Riverside Energy Park Examination – EN010093

Summary of the oral case put forward at the Issue  
Specific Hearing on Environmental Matters on 5 June  
2019

On behalf of  
Thames Water Utilities Limited

Submitted at Deadline 3  
18 June 2019

Noise Assessment Locations

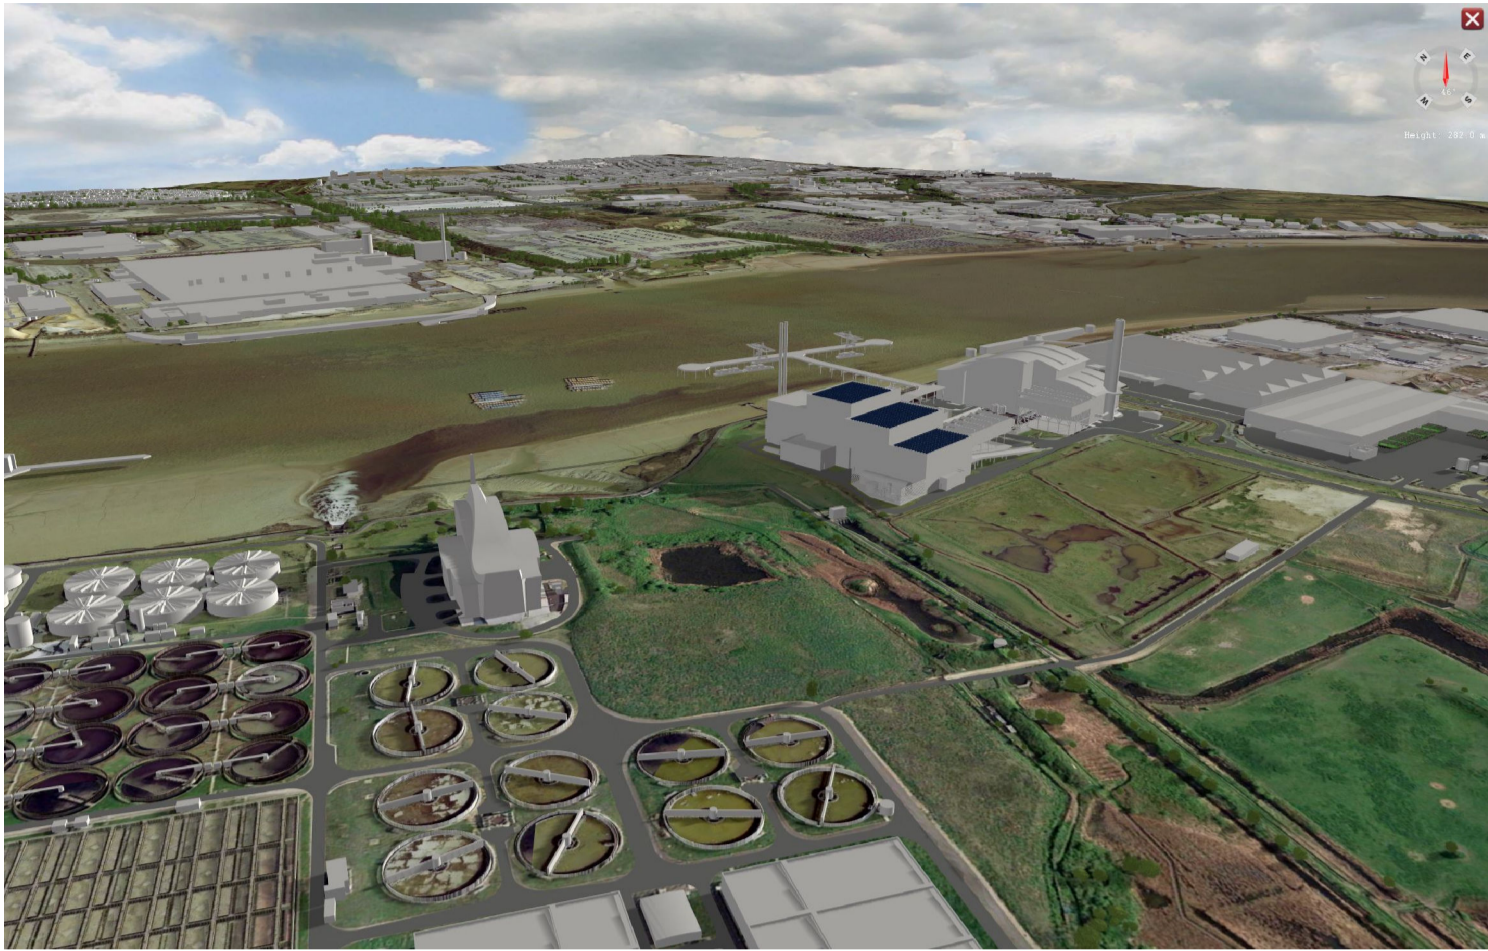
18. TWUL also made comments on the location of the noise sampling and modelling. Fig. 11.10 Noise Assessment Locations (Document 6.2 Environmental Statement Figures part 6 of 6) shows Location 3 to be by the entrance to the Protected Area on the footpath originally identified for the cable route. Peter Brett Associates state that the location is in fact in the south-west corner of the West Paddock, but this is not what the plan shows. For a more accurate assessment of noise impacts, the noise modelling assessment should be north of

the West Paddock, the area closest to the Project and the area in which breeding Lapwing occur.
